27 November 2019

M12 Motorway (SSI-9364)

SSI – 9364 M12 Motorway Penrith City Council Submission

The key features of the project are shown in **Figure 1-2**.

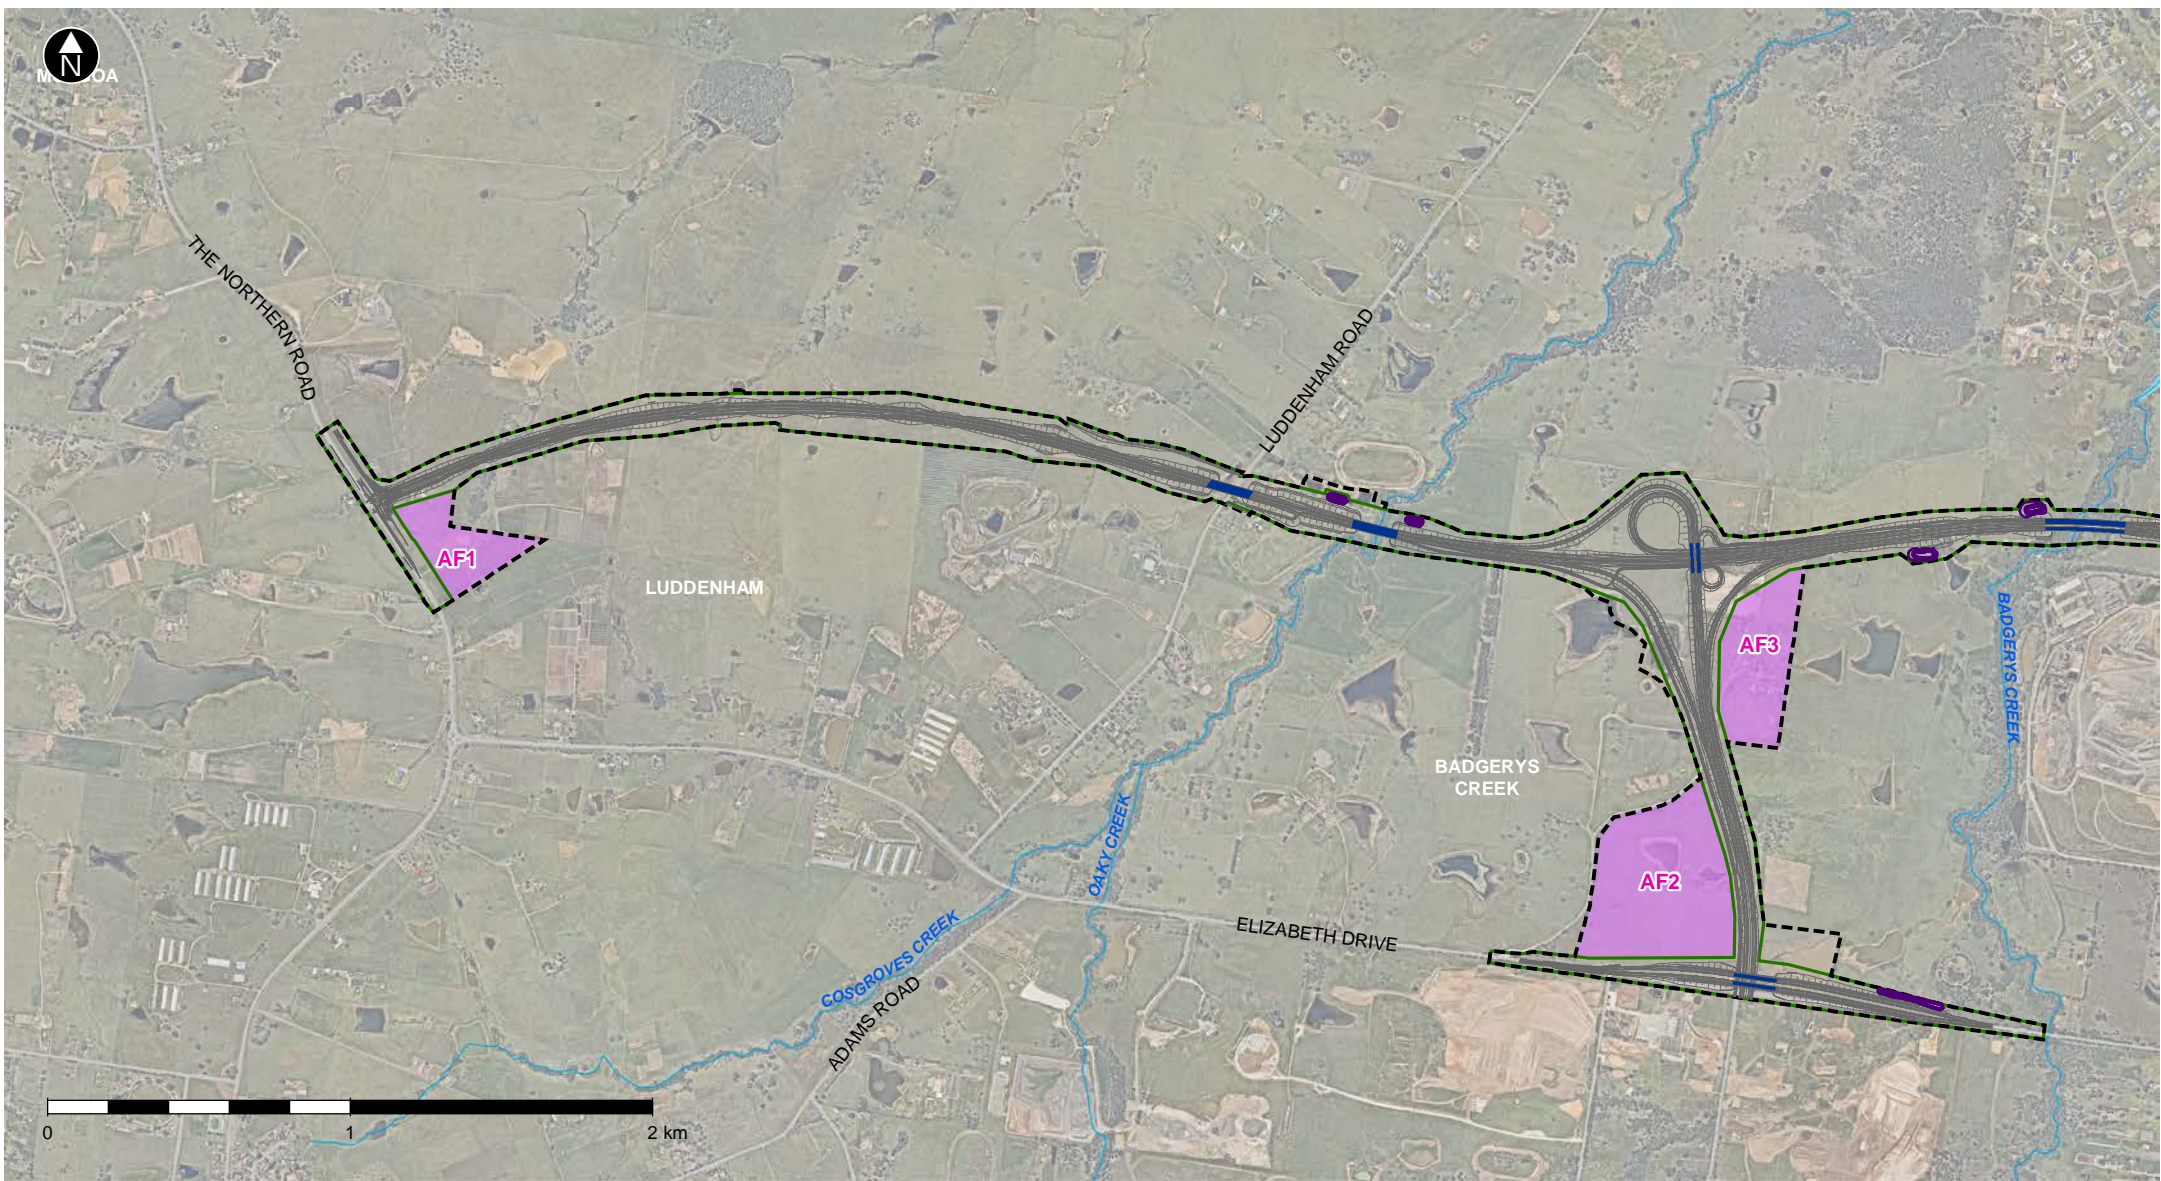
- Noting that the Western City is a key part of the rationale for the M12 proposal, there doesn't appear to be any inclusion of, or definitive provision for interchange into the Northern Gateway, which is an initial precinct within the Aerotropolis as envisaged in the Western Sydney Aerotropolis Stage 1 Land Use and Infrastructure Implementation Plan (LUIIP);

- It is therefore requested that the Devonshire Road interchange be brought into the proposal, or alternately be considered as a future extension in the plans (similar to the grade separation of the Northern Road, or the potential for widening to 6 lanes). It is also noted that the options analysis could be expanded to demonstrate this potential connectivity, as it would enable the opportunities and constraints of bringing forward such connectivity to be assessed;

- Currently there are no plans for an interchange with Elizabeth Drive. If interchange would be expected between the M12 and Elizabeth Drive through the airport road network, then this may be difficult to rely on given the Commonwealth ownership of airport lands and the inability for the NSW to ensure an airport related connectivity outcome over the long term. It is requested that this aspect be considered in the assessment of the application;
